OXFORDSHIRE COUNTY COUNCIL'S RESPONSE TO CONSULTATION ON THE FOLLOWING DEVELOPMENT PROPOSAL

Application no: 21/00503/F-2

Proposal: Use of the site for the storage of operational vehicles, elevational alterations, associated parking, vehicle barriers, guard hut and associated infrastructure

Location: 200 Southam Road, Banbury, Oxfordshire

Drawn by <b>MK</b>	Checked by <b>GPH</b>	Authorised by <b>JDG</b>
Scale <b>1:500</b>	Size <b>A0</b>	Date <b>Aug '21</b>
Drawing no. <b>10336-PL-400</b>		Rev. <b>D</b>

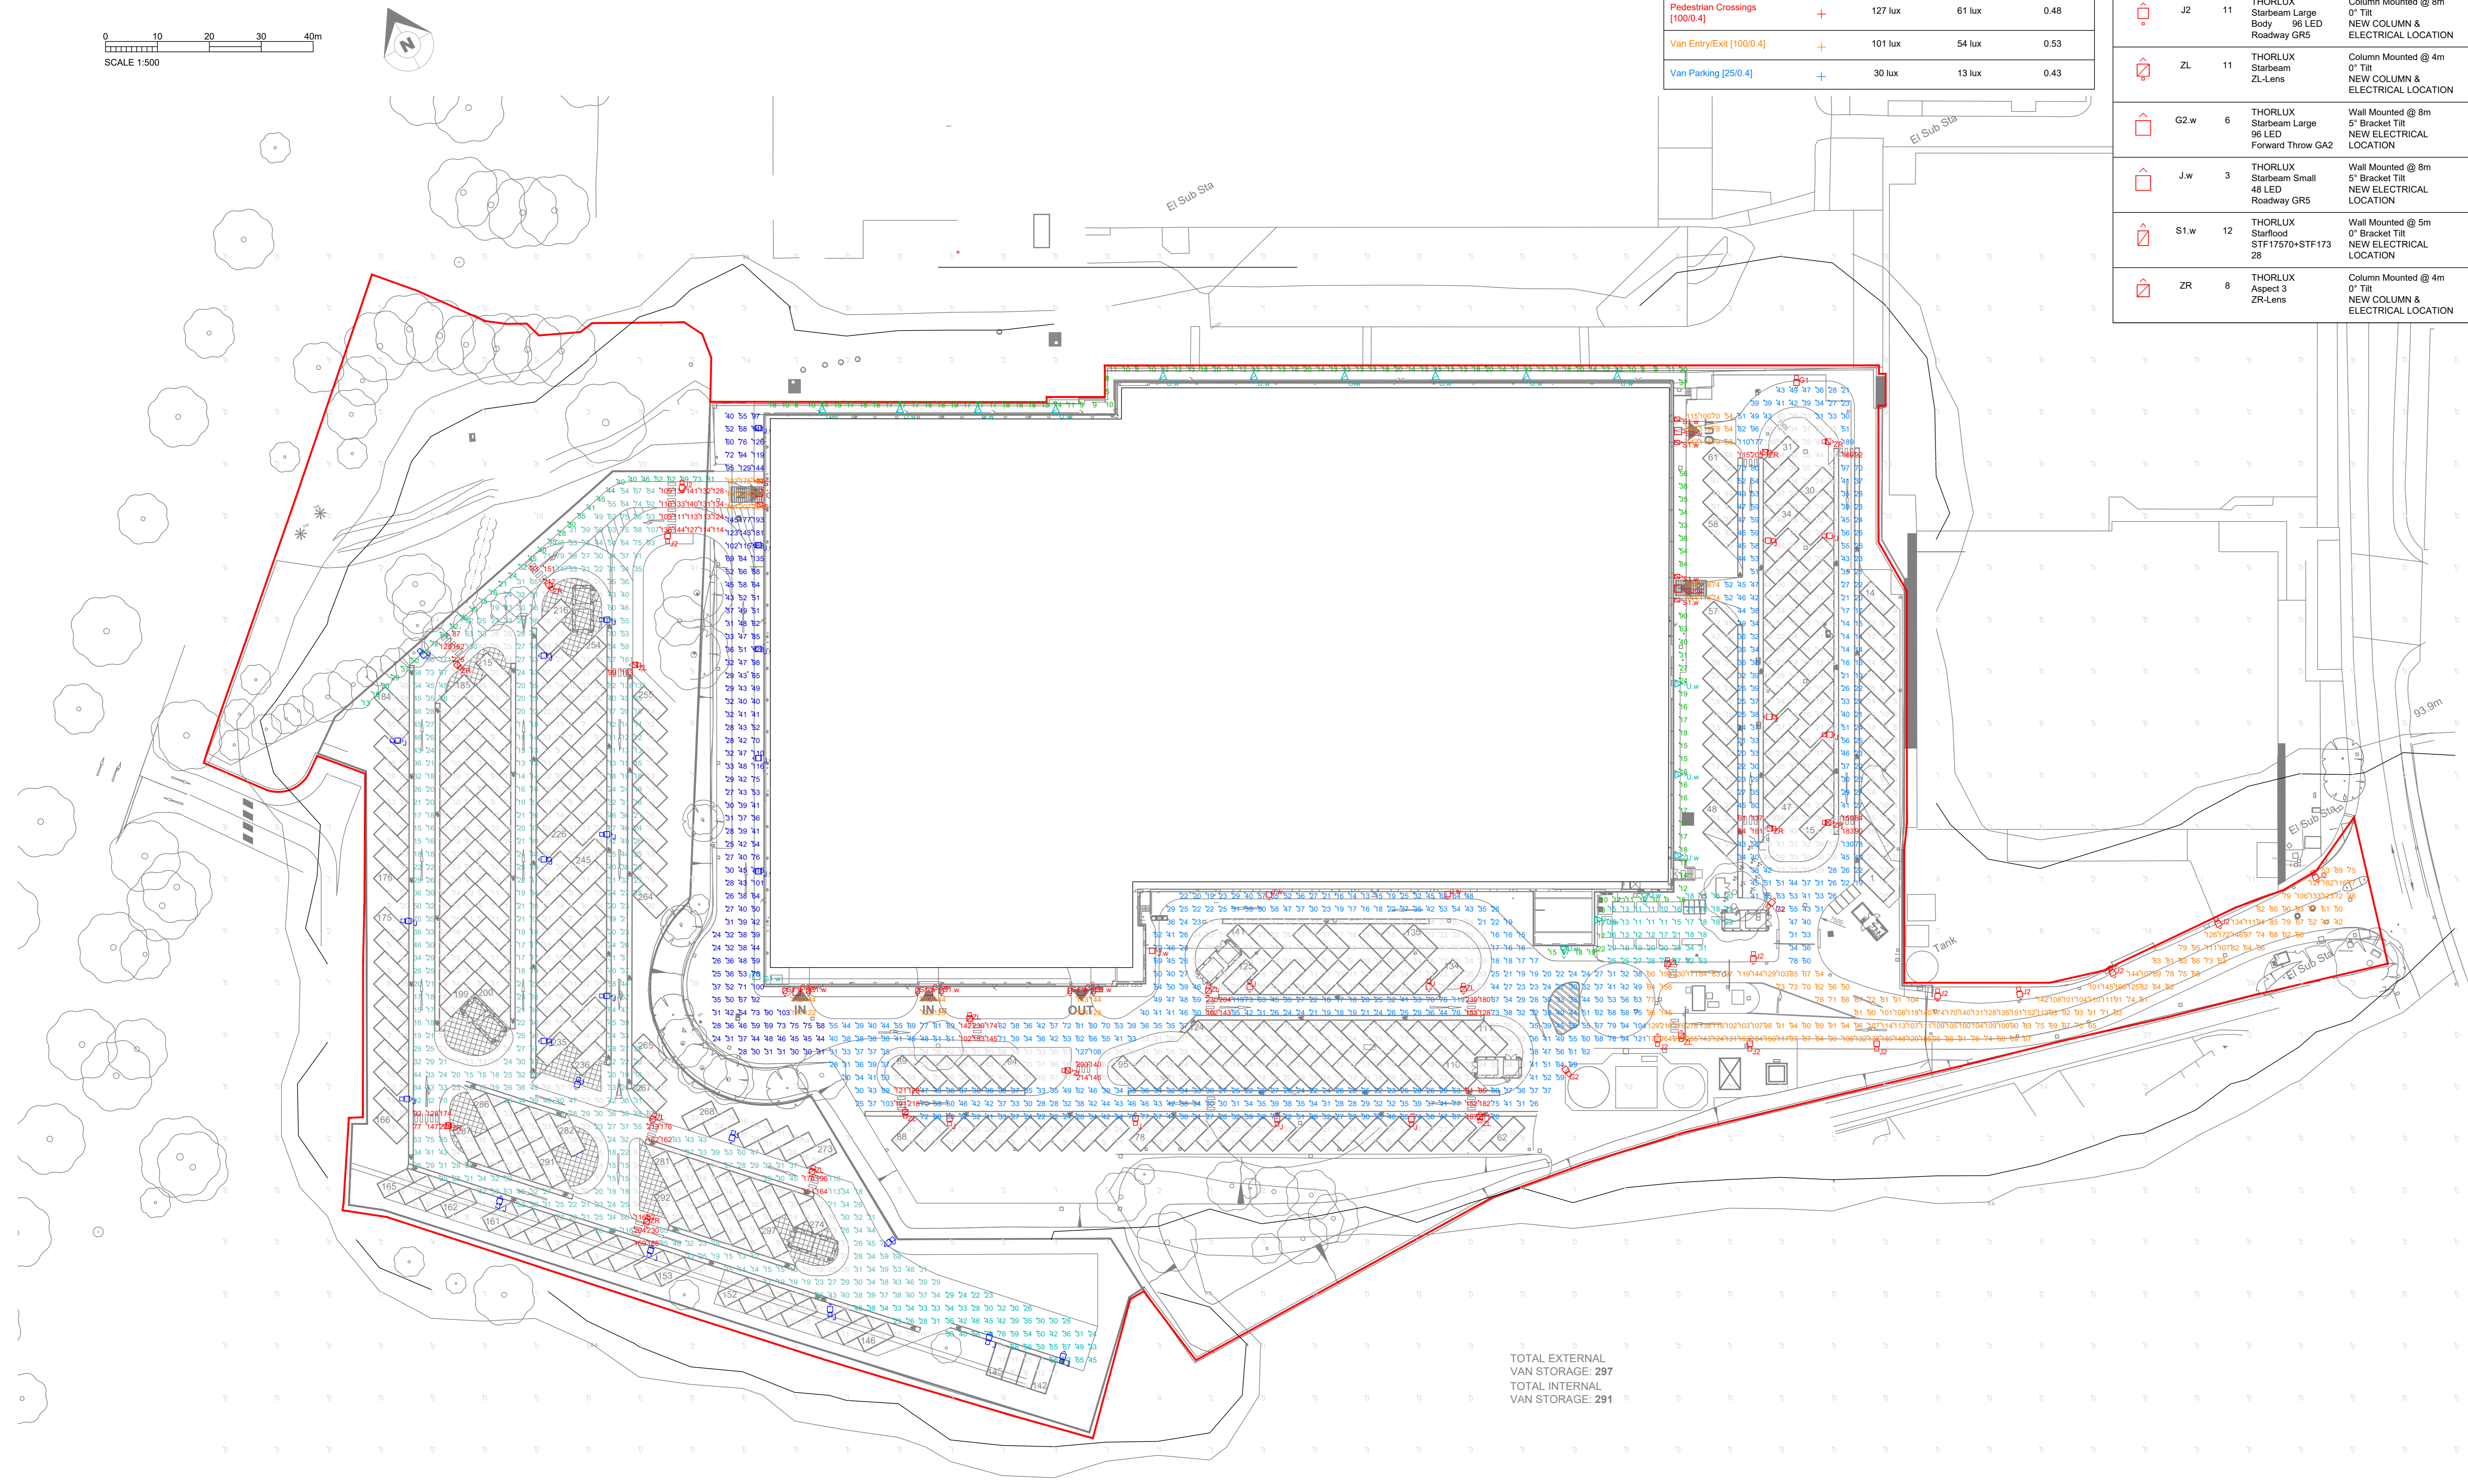
- The external lighting Lux Plot drawing no. 10336-PL-100 Rev OCC Street lighting Officers for comments, Applicant. The lighting arrangement is not be to OCC specification so required to establish if this road a private road.
There is no indication as to what category or classification the developer is trying to achieve with the lighting arrangement/levels. The lighting levels seem higher to what OCC would specify and the colour temperature is 4000k which is higher than we

would use which is 3000k. The light the fittings are similar to what we would approve.
